AB/32/20/DOC

Old Wheatsheaf House 31 Maltravers Street Arundel BN18 9BU

Approval of details reserved by condition imposed under reference AB/136/19/L relating to Condition Nos 3 - materials & finishes for external opening & proposed gate, 4 - materials & finishes for joinery (including windows &

Basement Staircase Plans

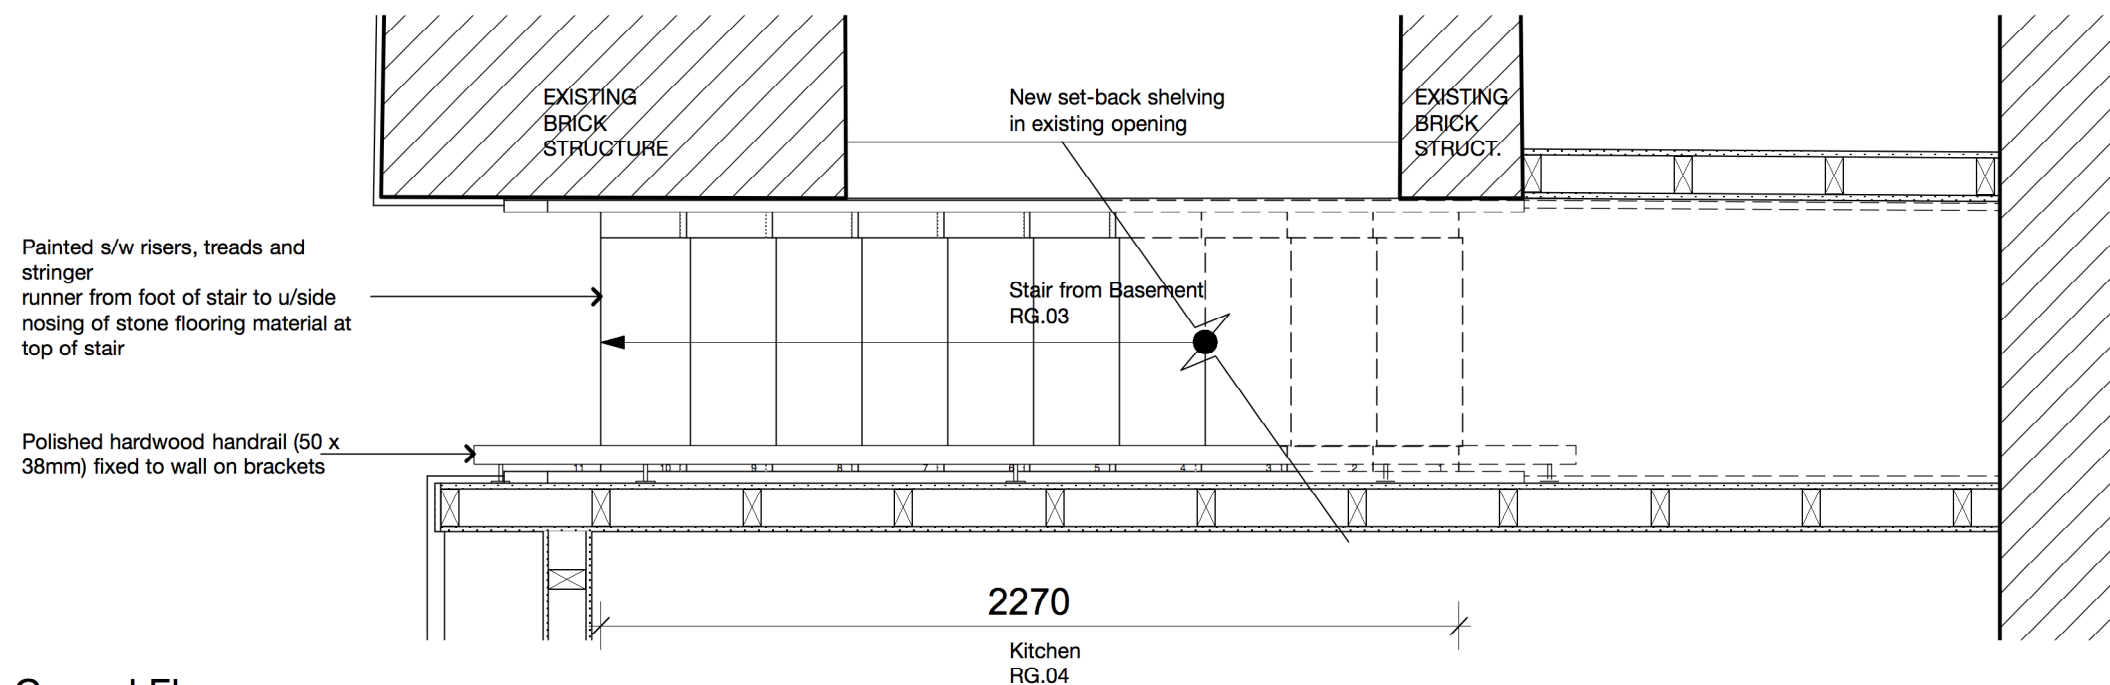
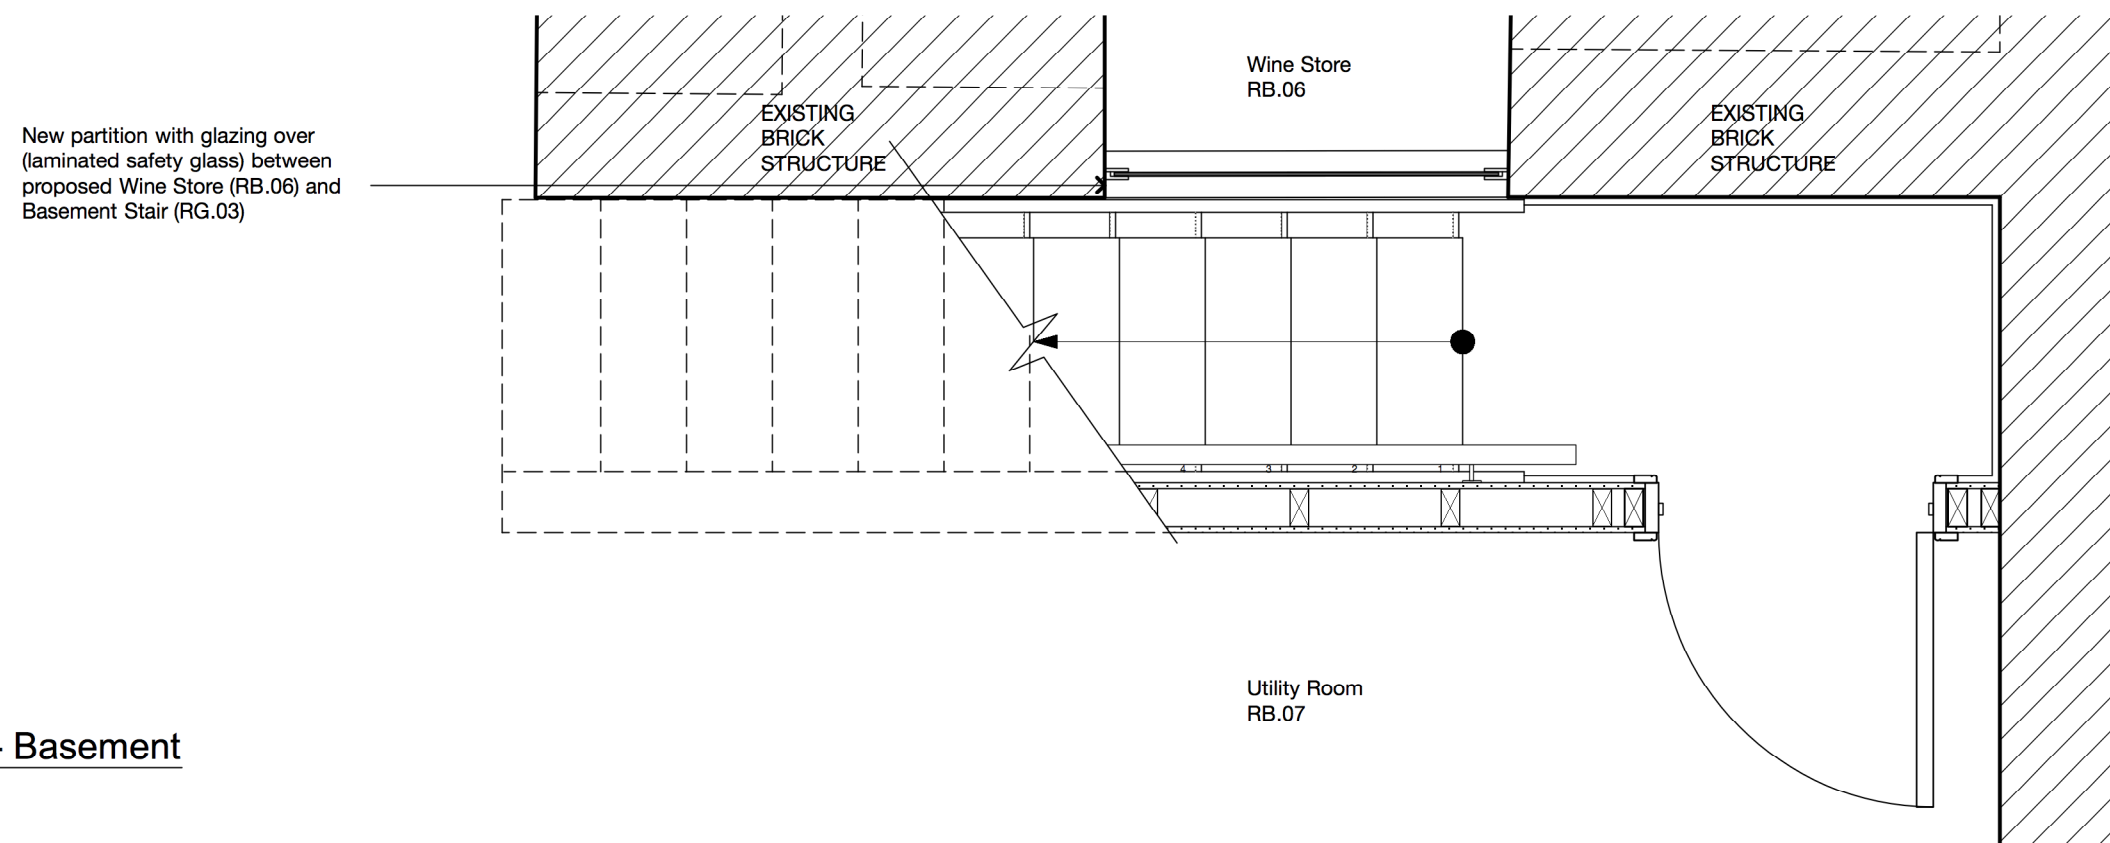
- It looks as if the staircase between the basement and the ground floor is to be enclosed at the basement level even though this did not appear on the proposed plans – this seems to be acceptable

Door Type G
DB.15
Basement - Games Room

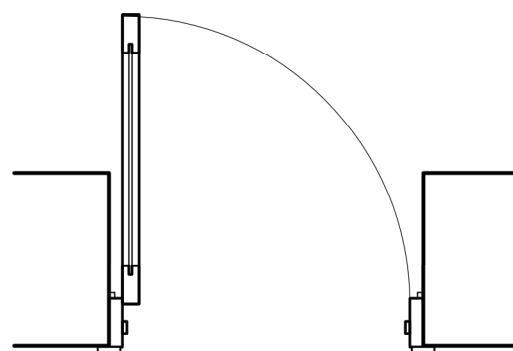
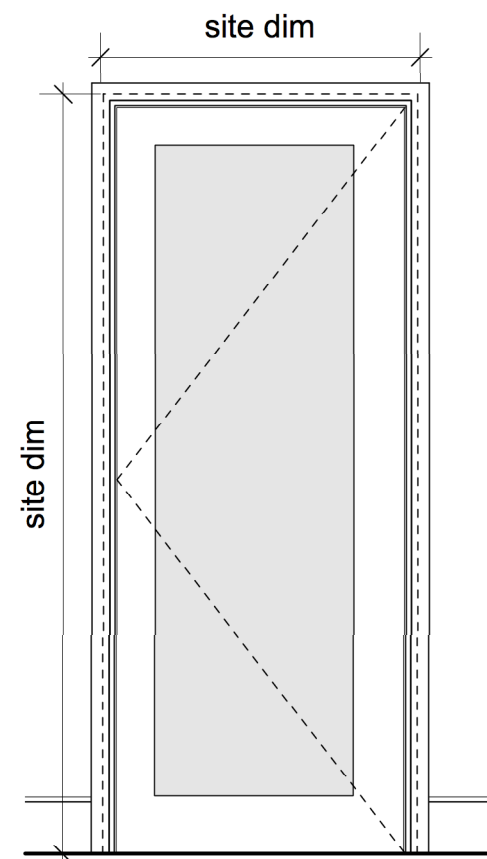
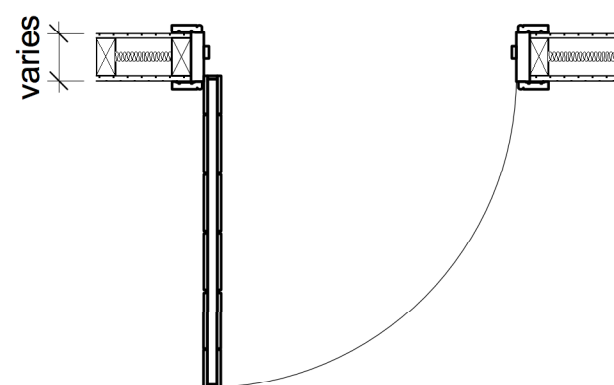
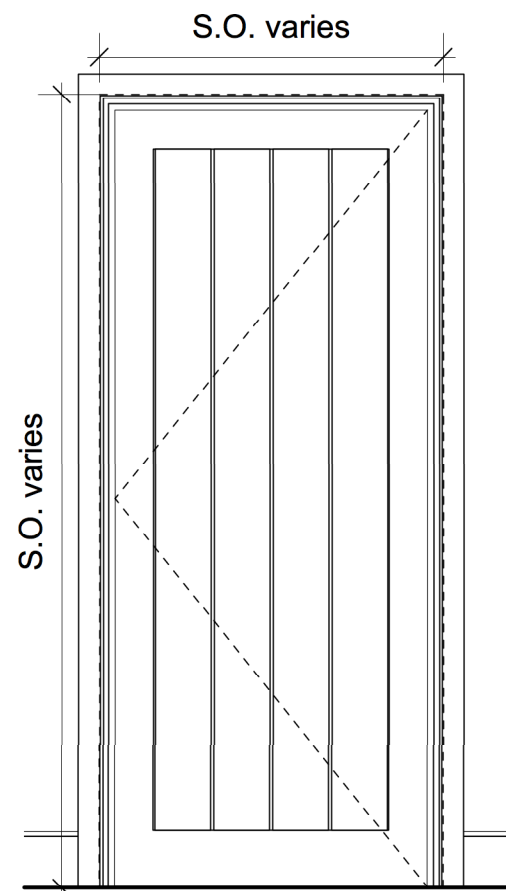
- Door type G also appears to be new when compared to the proposed basement floor plan of the listed building consent (i.e. not on the proposed plans). However, it appears to be acceptable.

Door Type H
Throughout interior, all levels

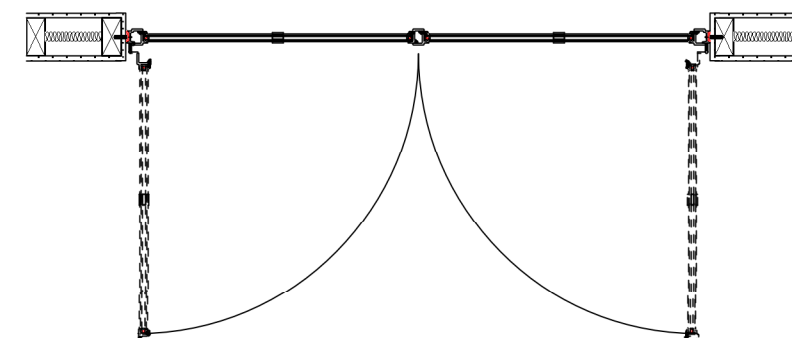
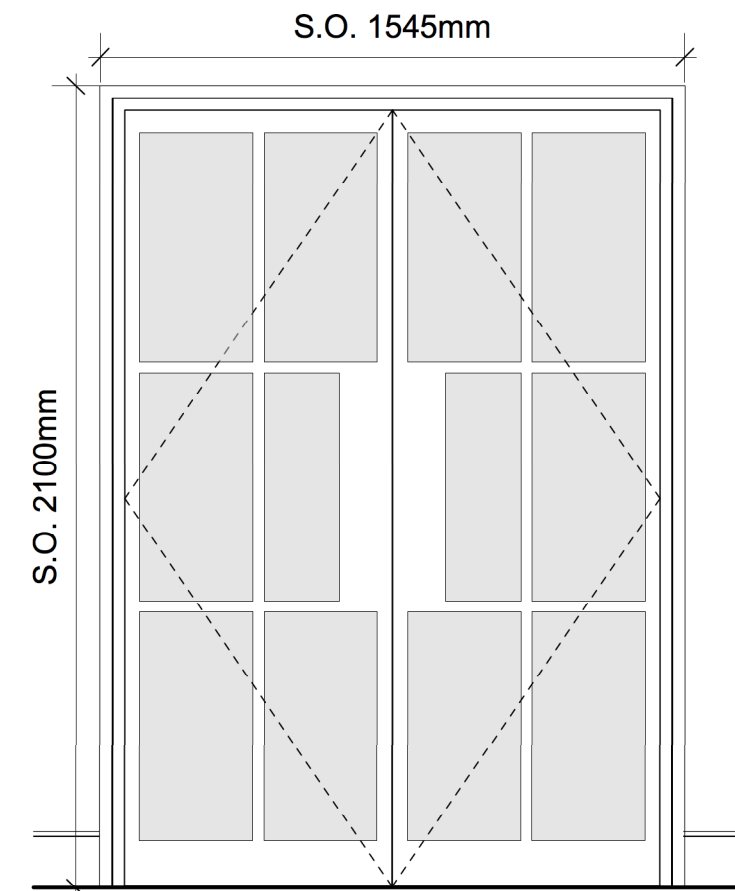
- The 'type h' doors will ultimately have a neutral impact upon the building and can be accepted in this instance.
- It is noted that fencing is included on the garden plans (above the boundary wall) – was this included on the original consent?

JOB TITLE			
									31 Maltravers Street, Arundel			
									DRAWING TITLE			
									Proposed External Doors - 1			
									DRAWN			
									DATE			
									SCALE			
									PC

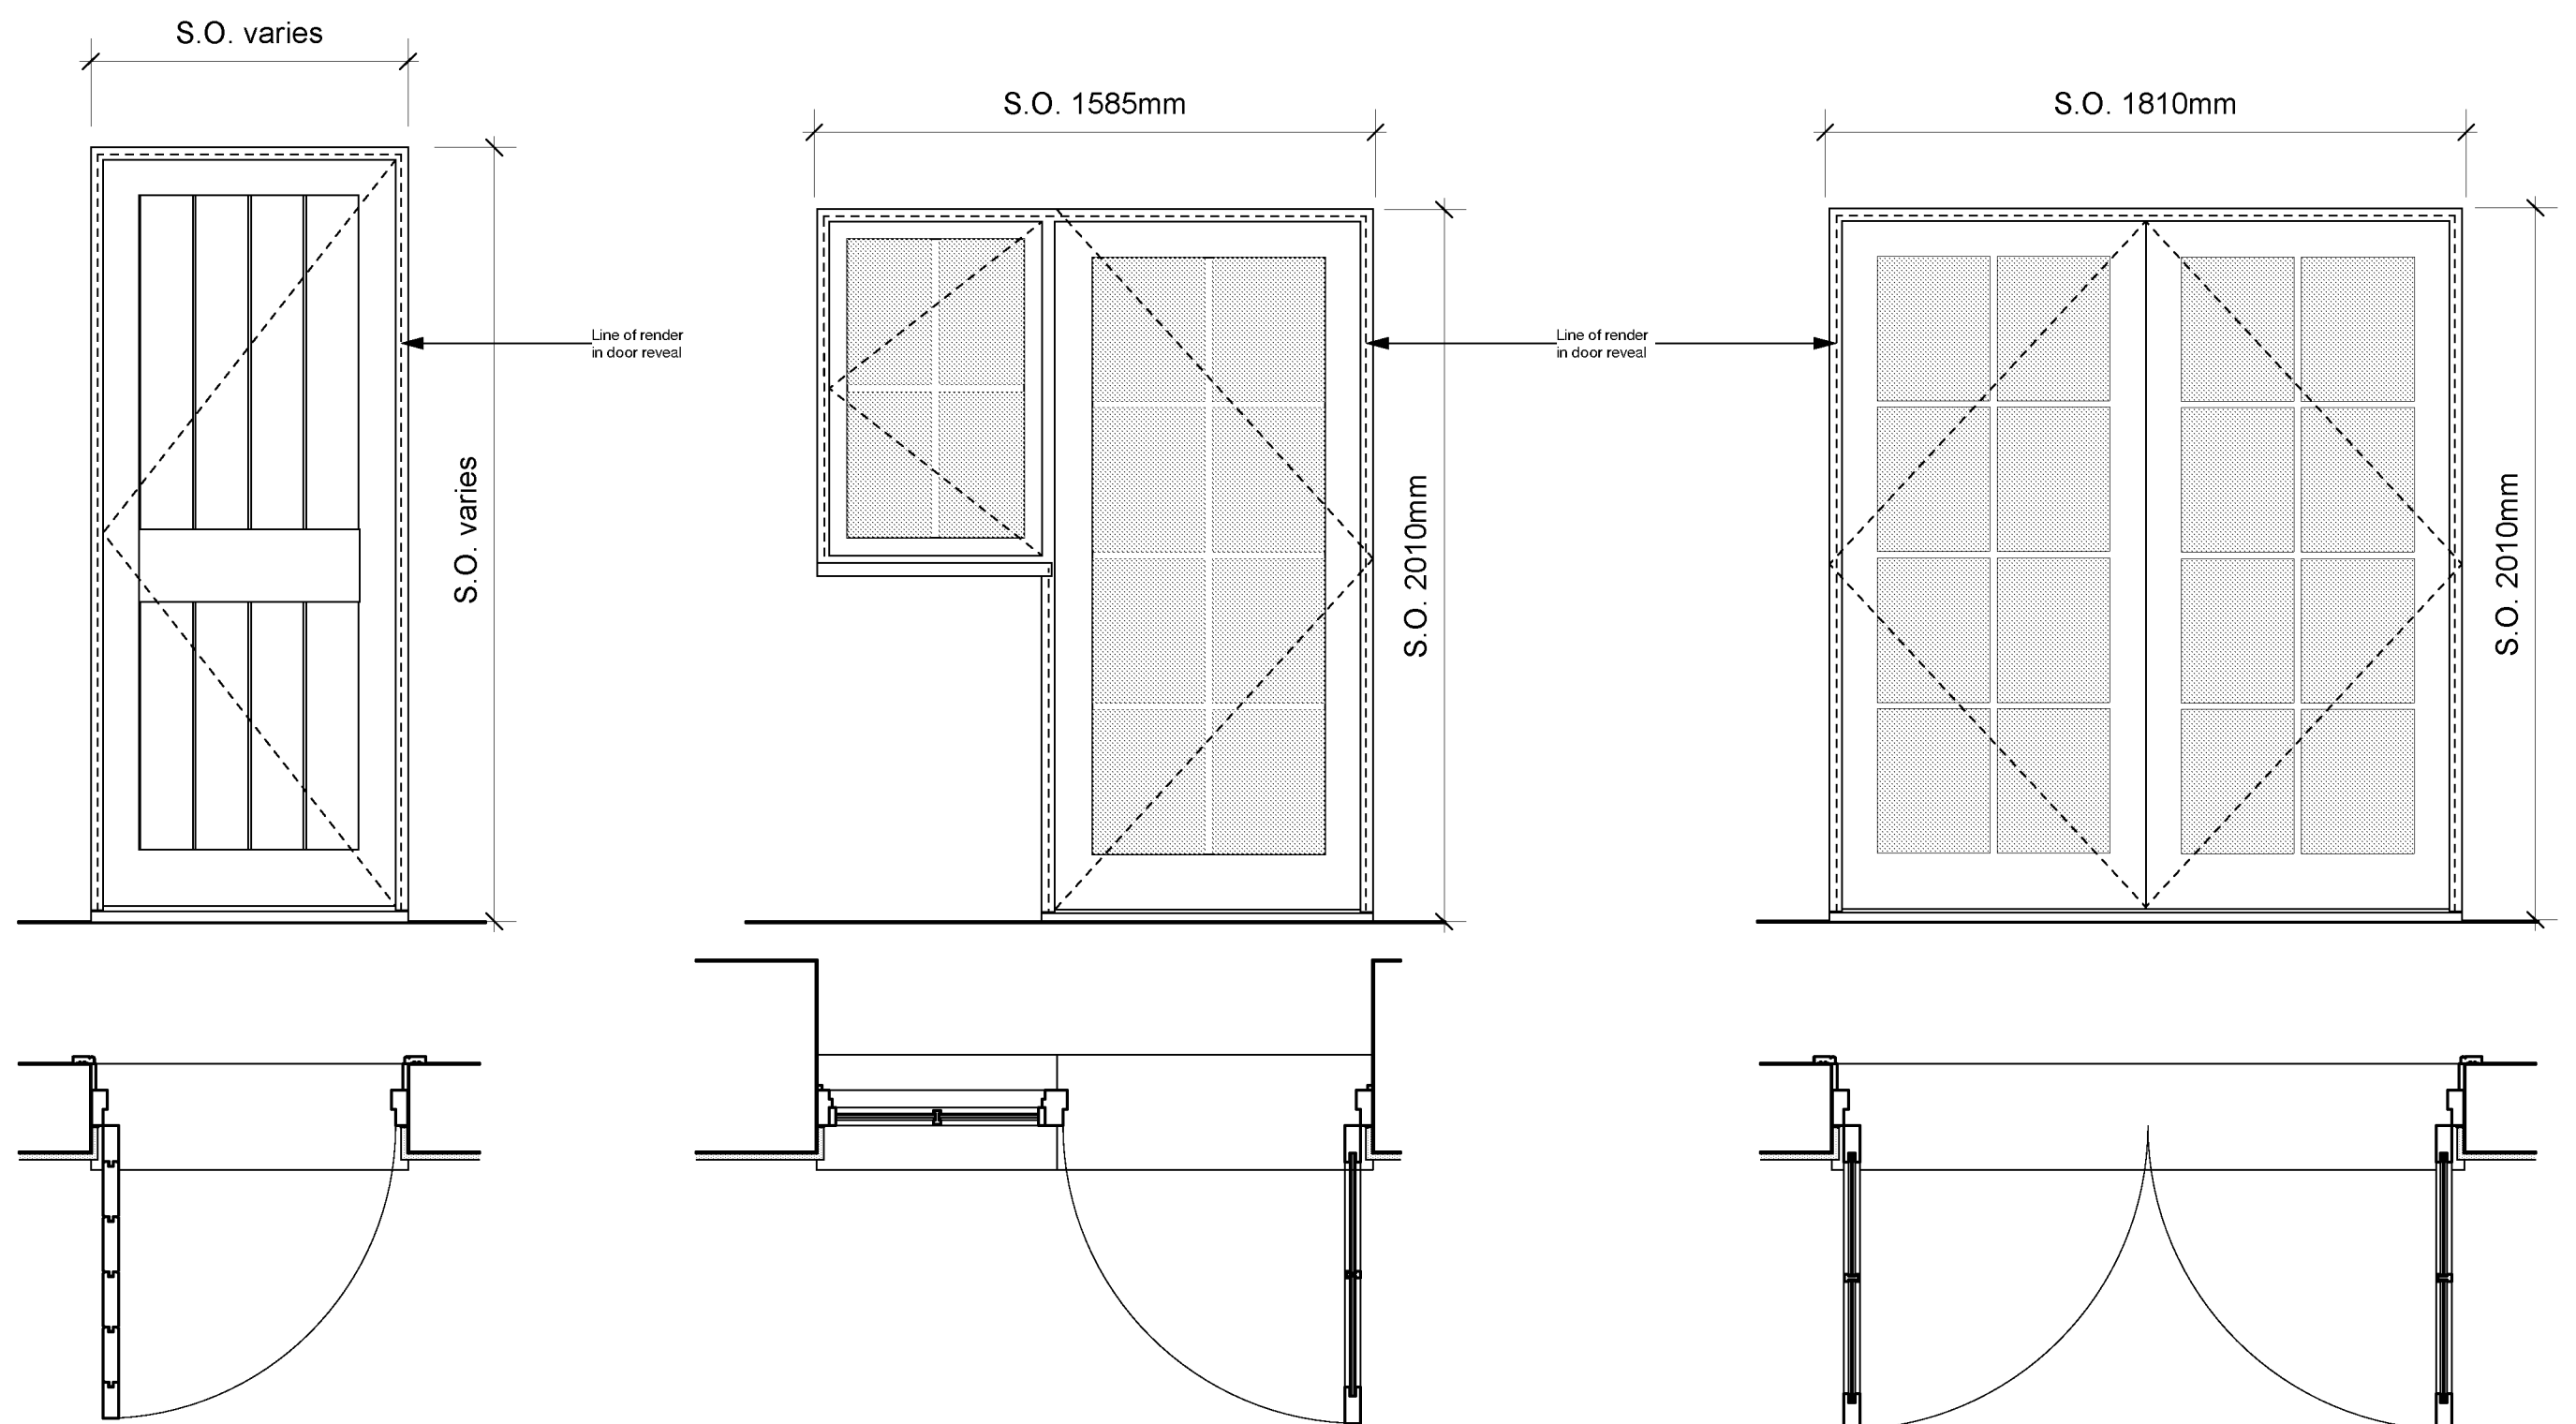
- Door type B – DB02 – it is assumed that this is the entrance door for the annex? If this is the case, this is different to the approved plans in that it now includes a window to the side of the door. It is also not clear why the window has to be top-hung? I also cannot see any details for the annex living room French doors – have I missed them?

- It is also not possible to see the detail related to the proposed glazing bars on the two sets of door plans provided. Will they be integral to the or applied?
